CITY OF ALBUQUERQUE

**RE: Lot 24 Rancho Guadalupe
1616 Rancho Guadalupe Trail
Request for Permanent C.O. - Accepted
Engineers Stamp Date 11/21/14 (F13D002C)
Certification Dated: 8-13-15**

**Re: Lot 24 Rancho Guadalupe Subdivision
Grading and Drainage Plan
Engineer's Date 11-21-14 (F13D002C)**

**Re: Lot 24 Rancho Guadalupe Subdivision
Grading and Drainage Plan
Engineer's Date 10-16-14 (F13D002C)**

GRADING AND DRAINAGE PLAN

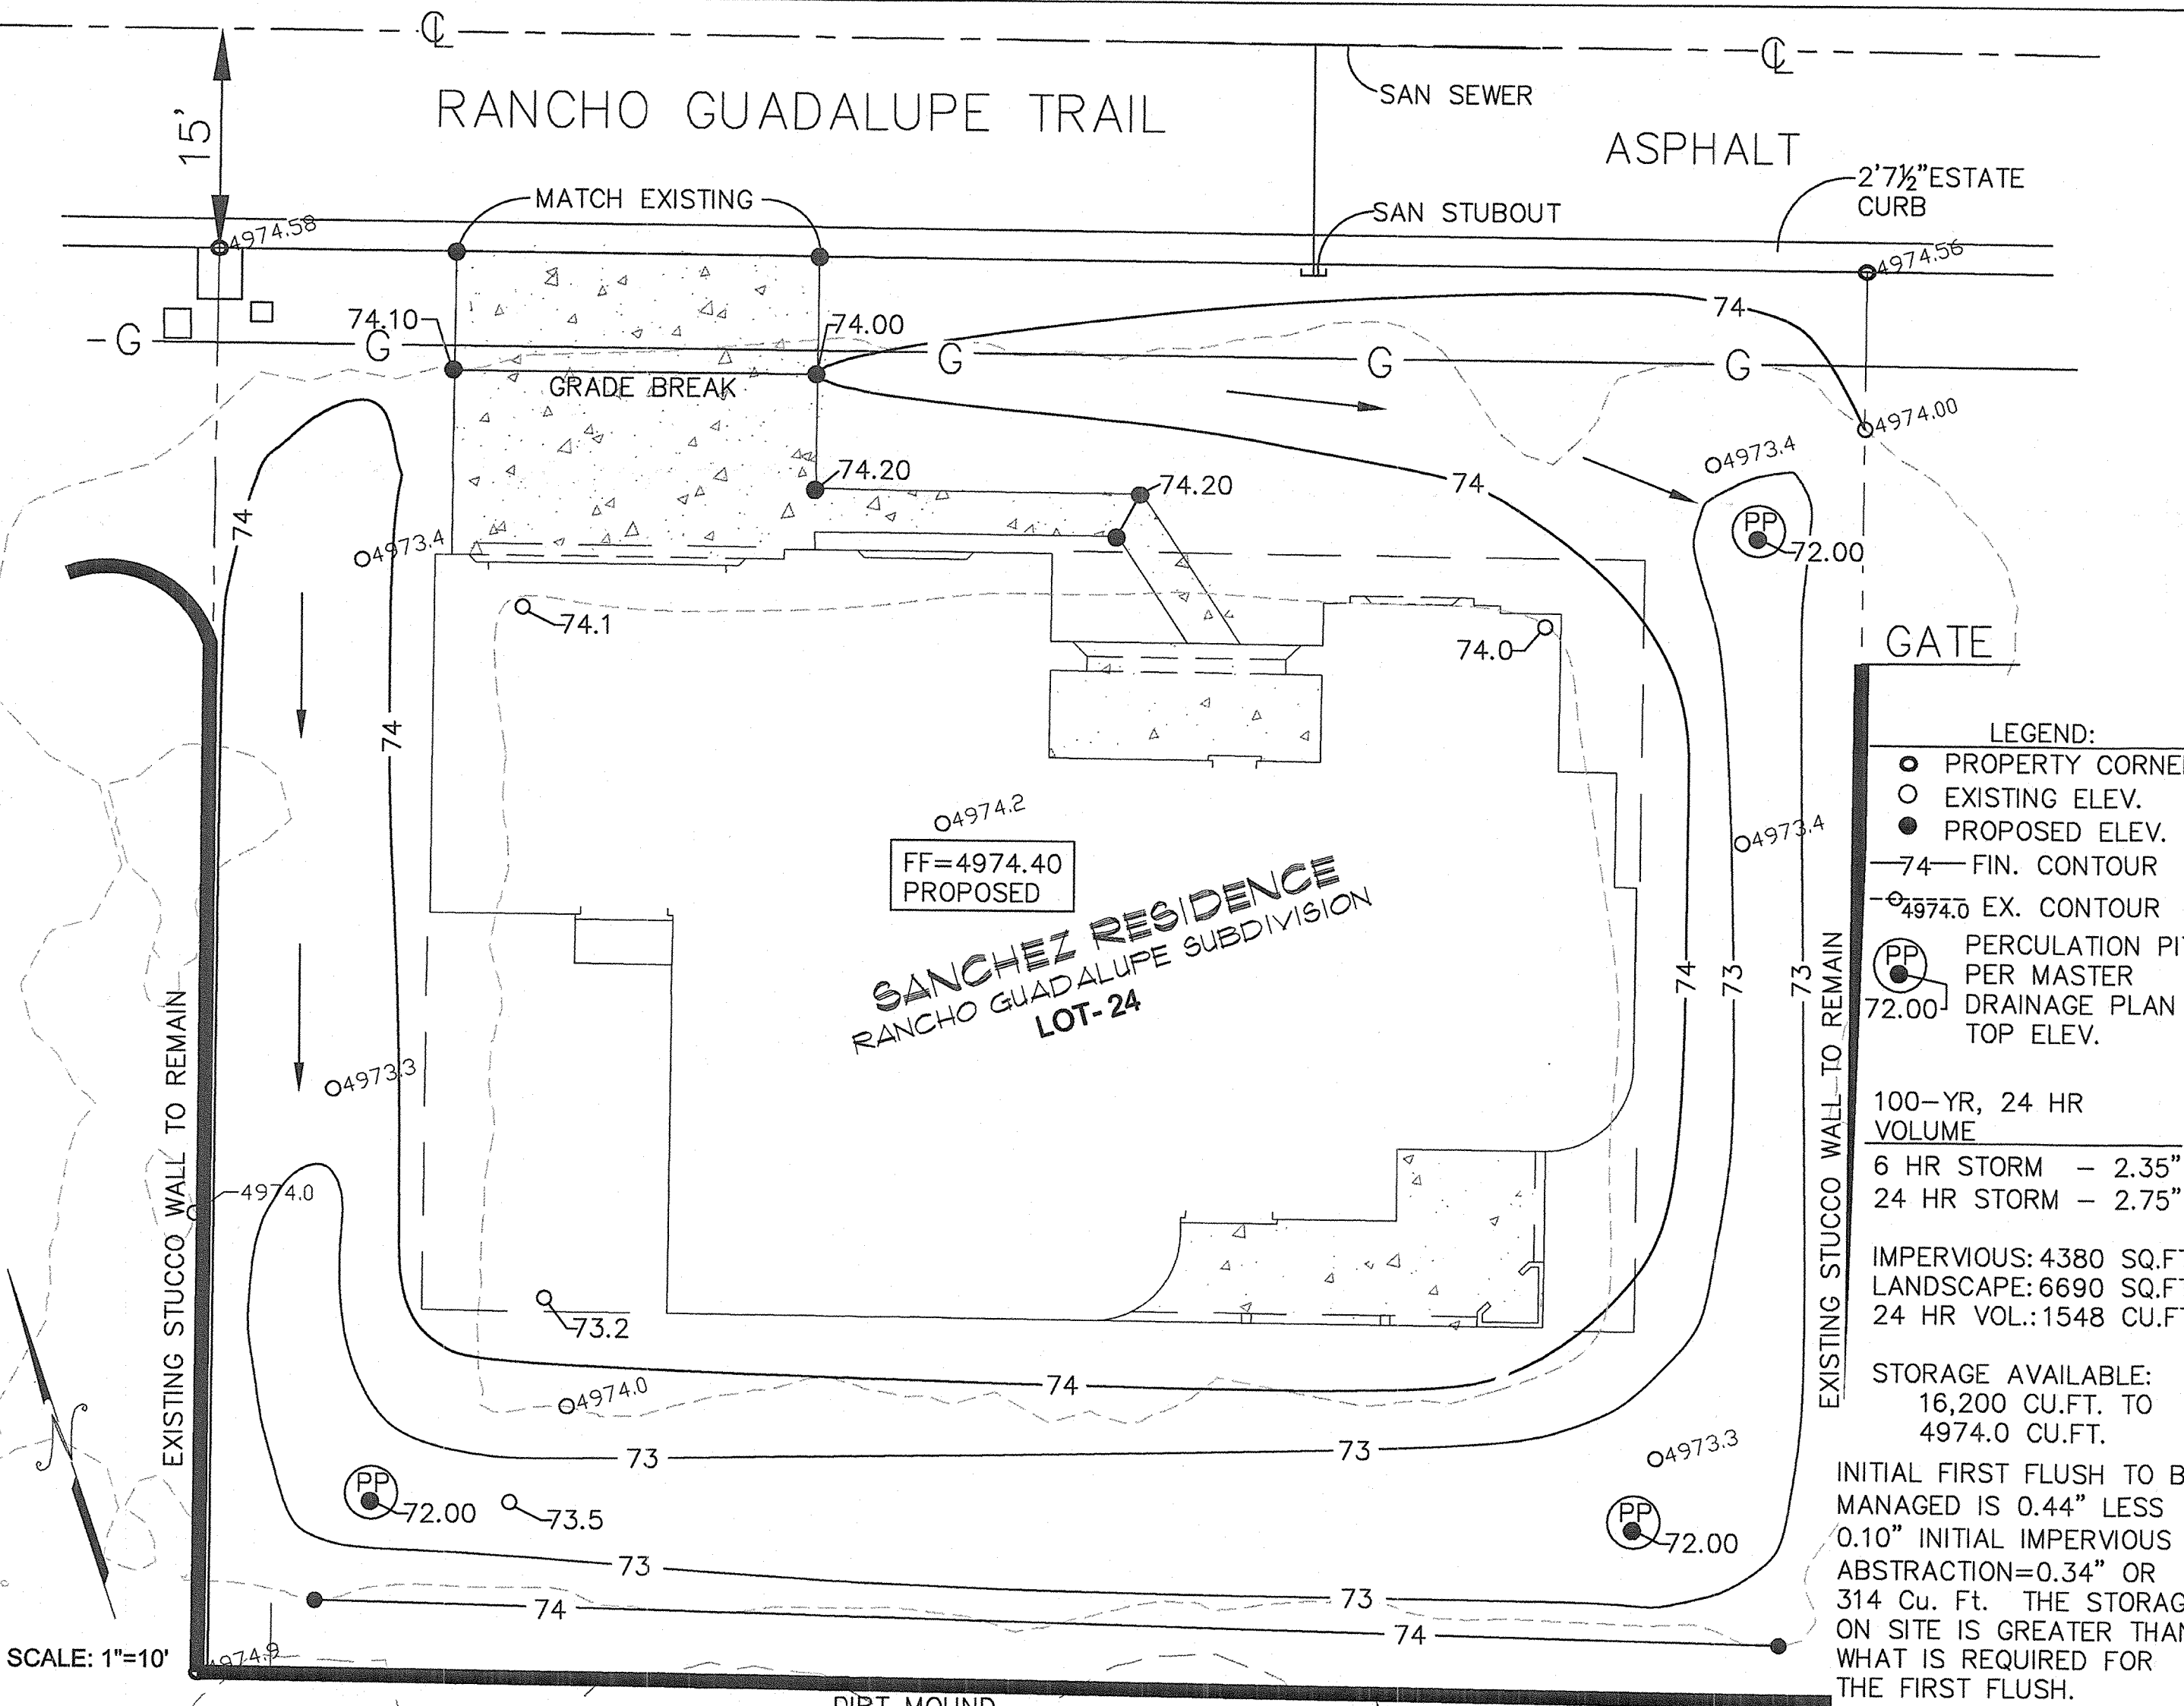
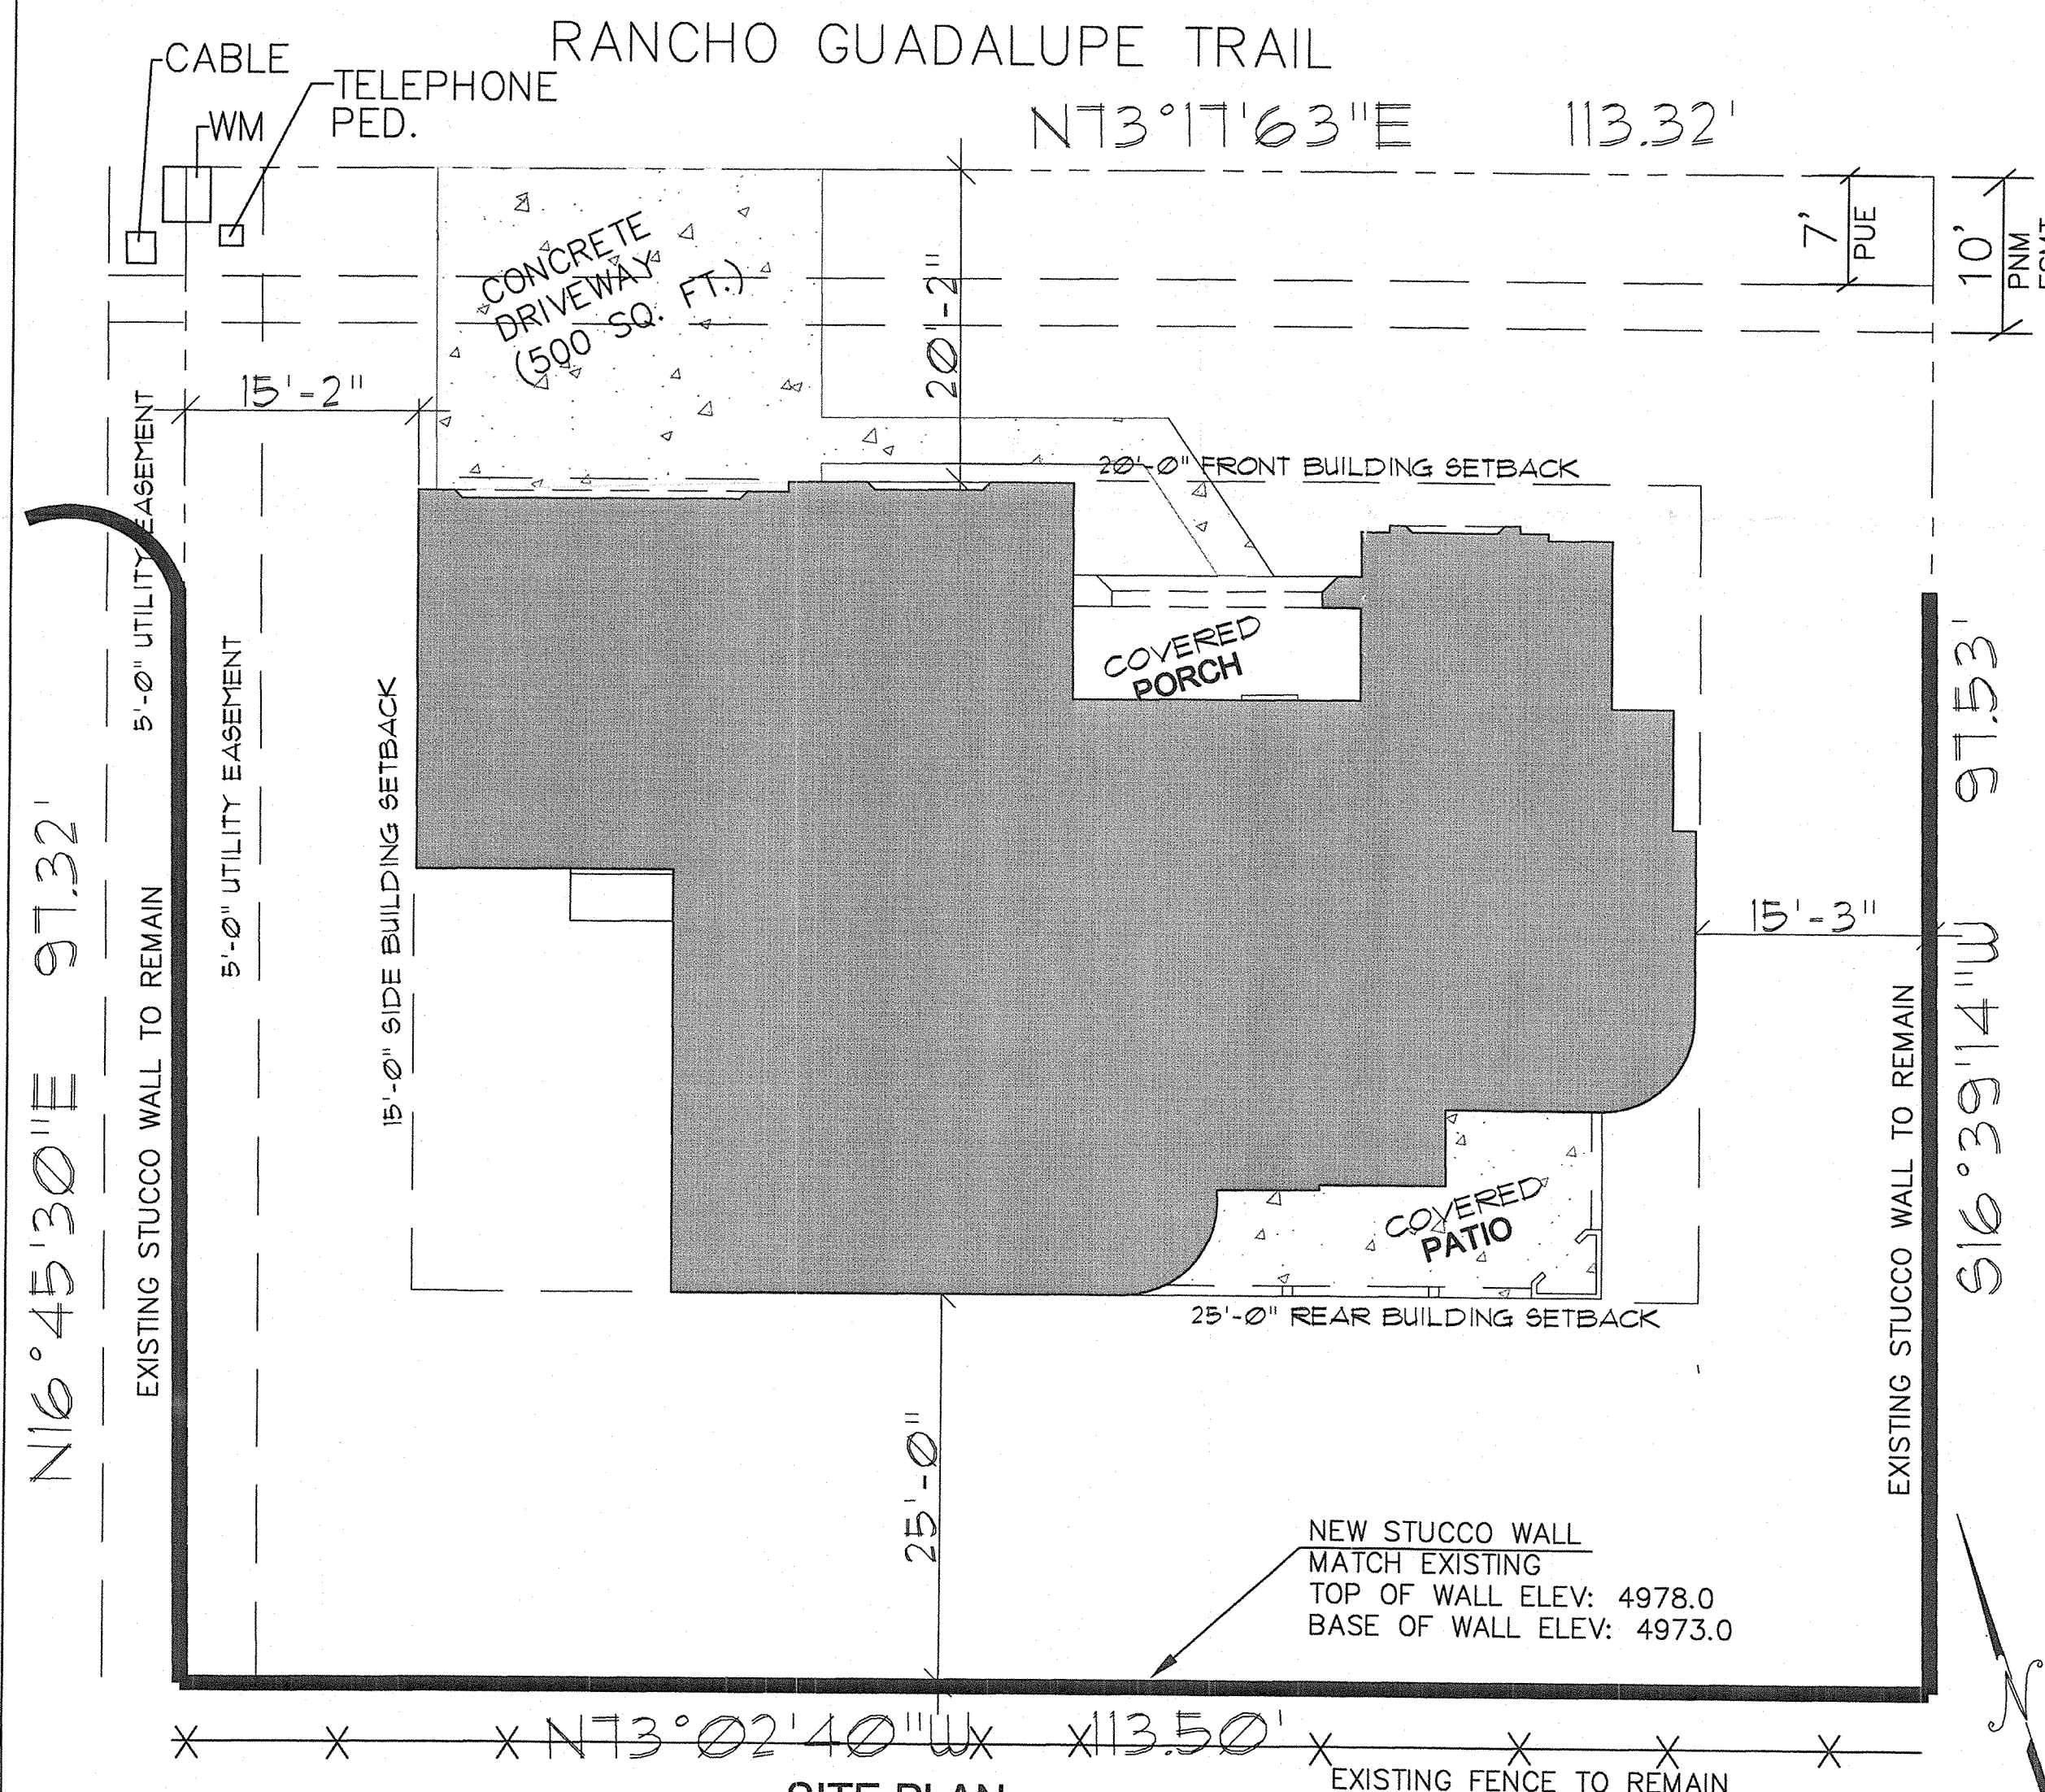
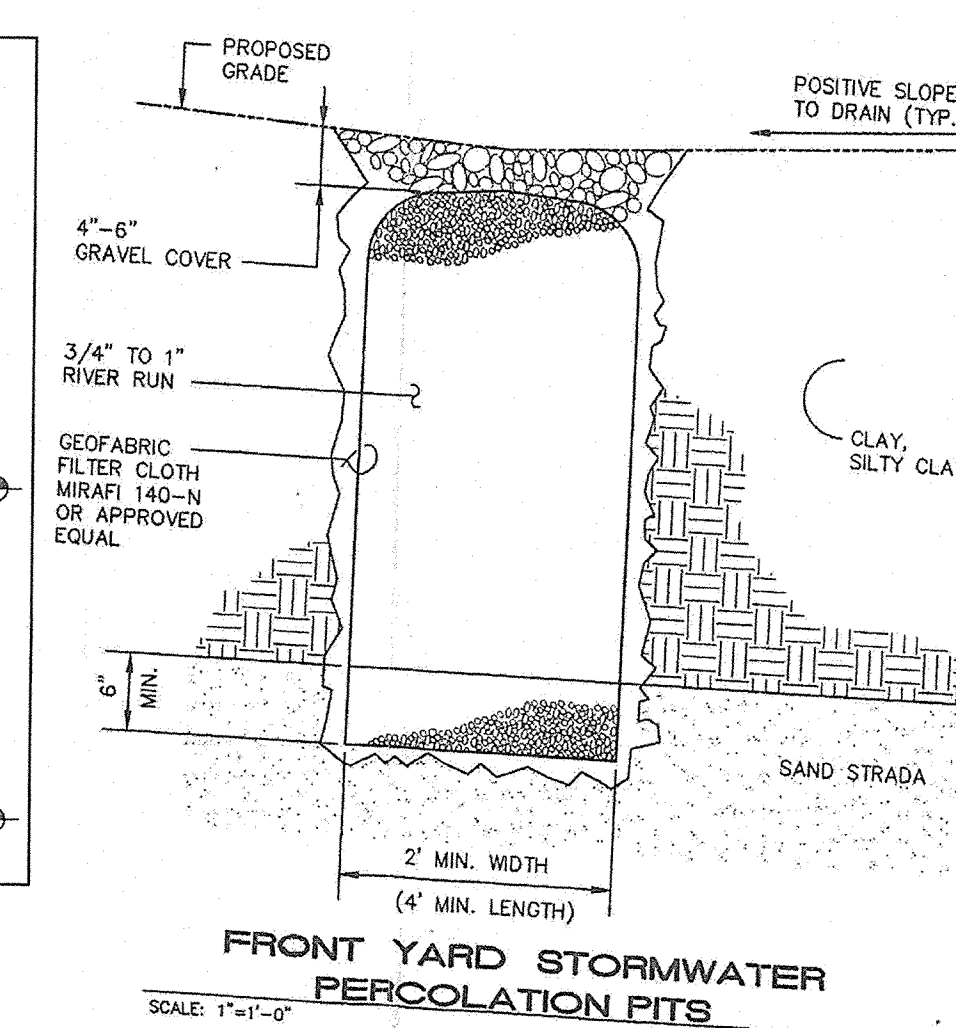
The correct First Flush amount is 0.34 times the impervious area of the site (4380 sf) which totals to 924 cf not 314 cf as stated on the plans. The ponding area is more than adequate for this. Please note this for future submittals to Hydrology.
